From: [Peter](#)
To: [YorksHumberCCSPipeline](#)
Subject: EN070001 - Written Statement/ accompanied Site Inspection, Hearings attendance
Date: 15 December 2014 16:26:55
Attachments: [WRITTEN REPRESENTATION - Glendon Estate.docx](#)

WRITTEN REPRESENTATION

**Application for Development Consent Order (DCO)
YORKSHIRE & HUMBER CCS CROSS COUNTRY PIPELINE
EN070001**

DRG No 10-2574-PLN-01-1049

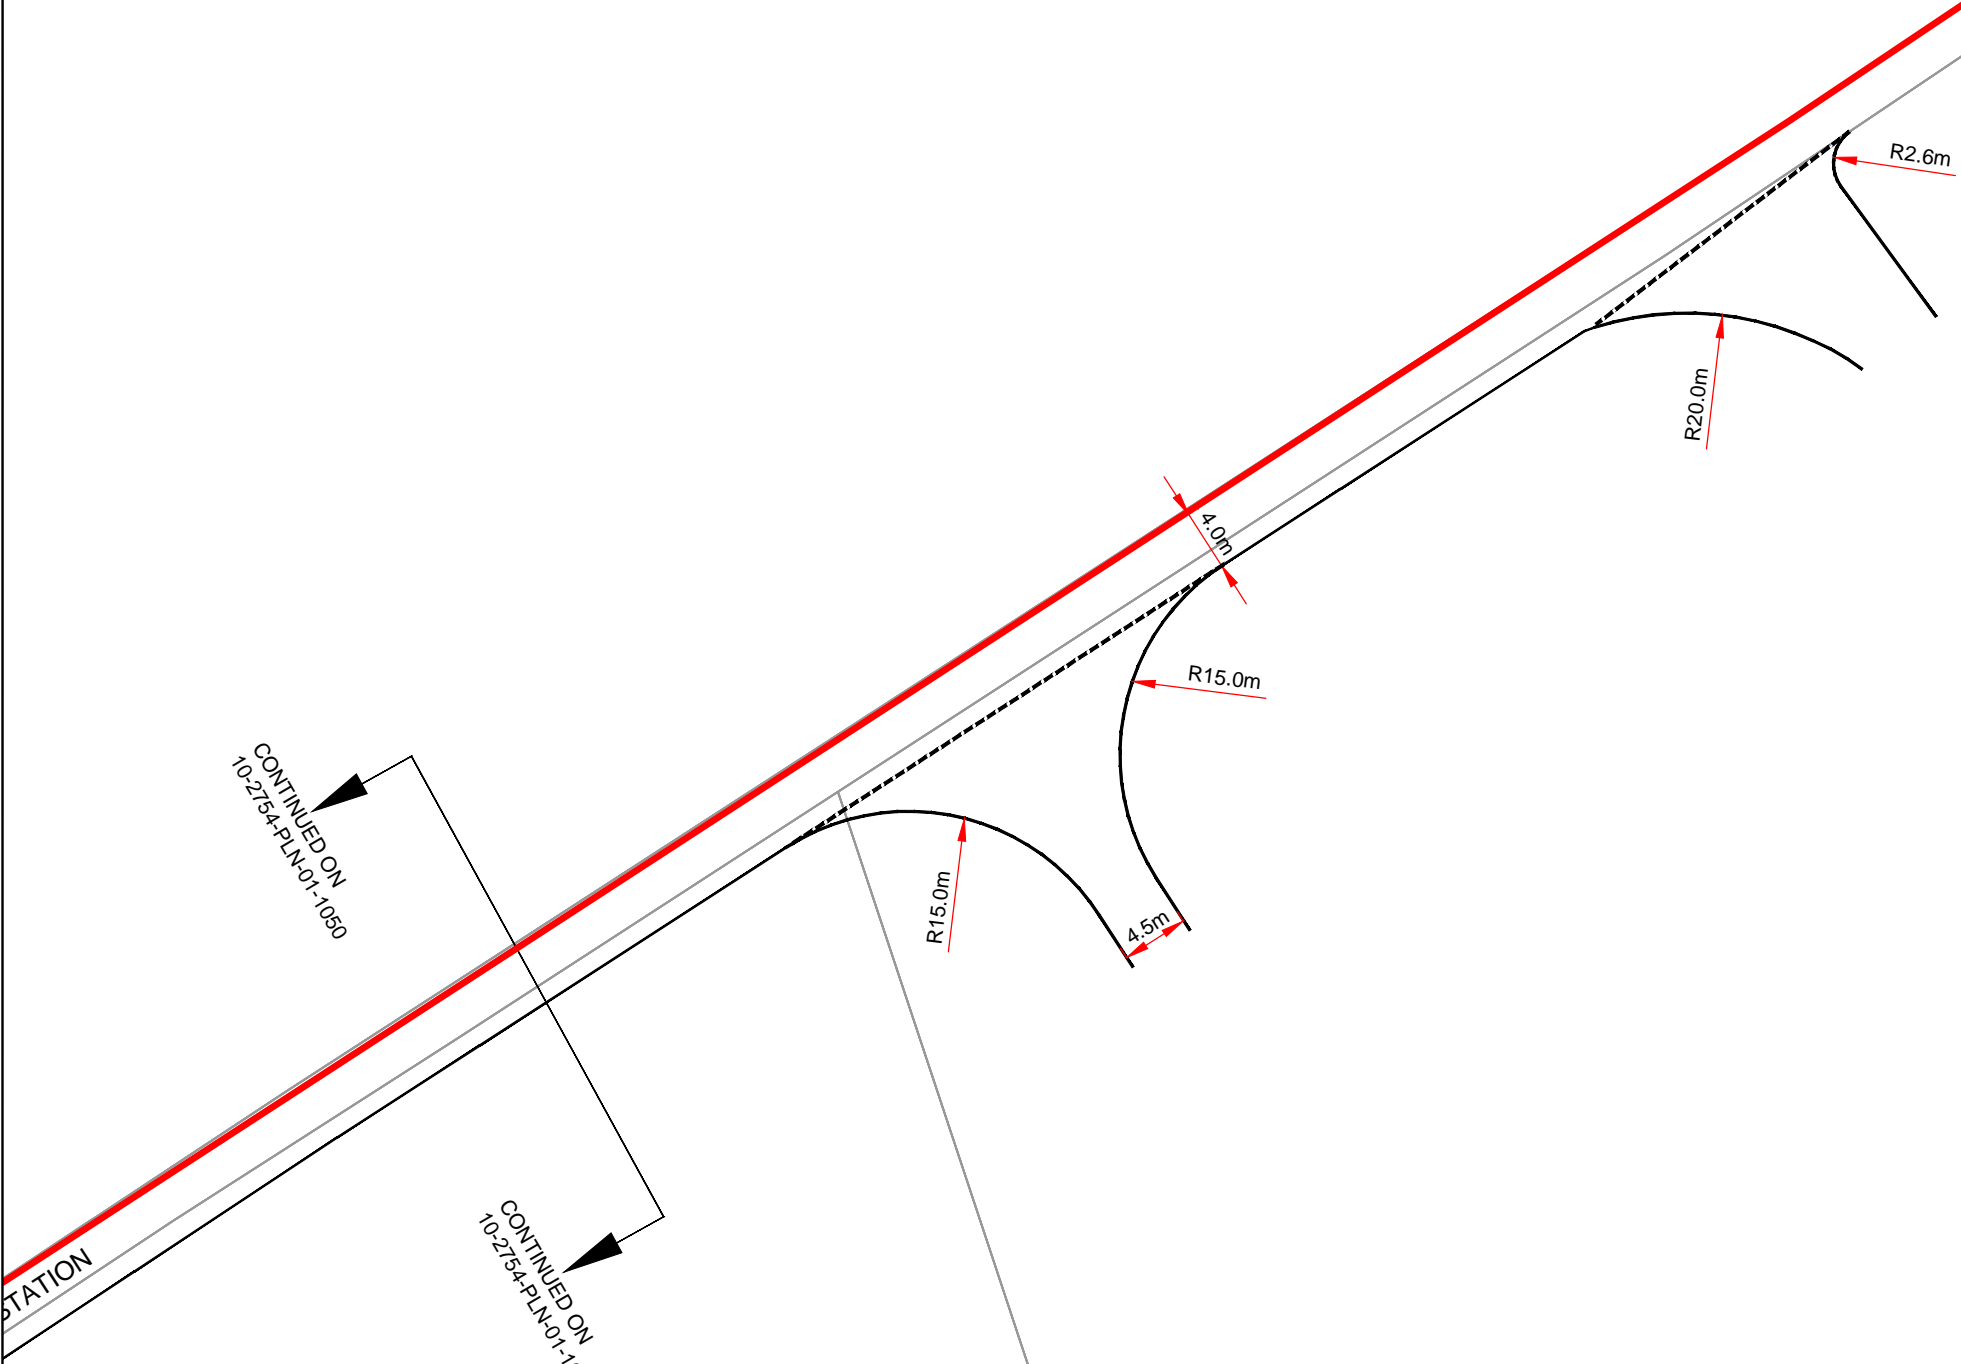
- The Developer has moved the Pumping station site at the request of the landowner to arrive at the proposal location.
- One of the reasons for this suggestion was that the site would be nearer a public road for construction access purposes (the 'back' road to Fraisthorpe village) being accessible directly from the A165

- Despite this being a single track road the distance between hedges is sufficiently wide to install temporary or permanent passing places along its length and visibility at the Highway junction is likely to be better than the proposal access.

- The proposal requires access for all heavy construction traffic along the working strip to be taken for the pipeline route between the A165 and the proposed pumping station

- This means that heavily laden vehicles and heavy machinery will access the Pumping station site across agricultural land with surfacing works to try and prevent such heavy traffic from becoming bogged down

- The weight of such traffic will have serious and long reaching implications for soil structure along this part of the pipeline route once returned to agricultural use, no matter what assurances are given by the developers regarding reinstatement.

- **All construction vehicle access to the Pumping Station site should be via the single track public highway from the A165 at the junction nearest Stonehills Cottages with suitable improvements to passing places added by the developer where necessary.**
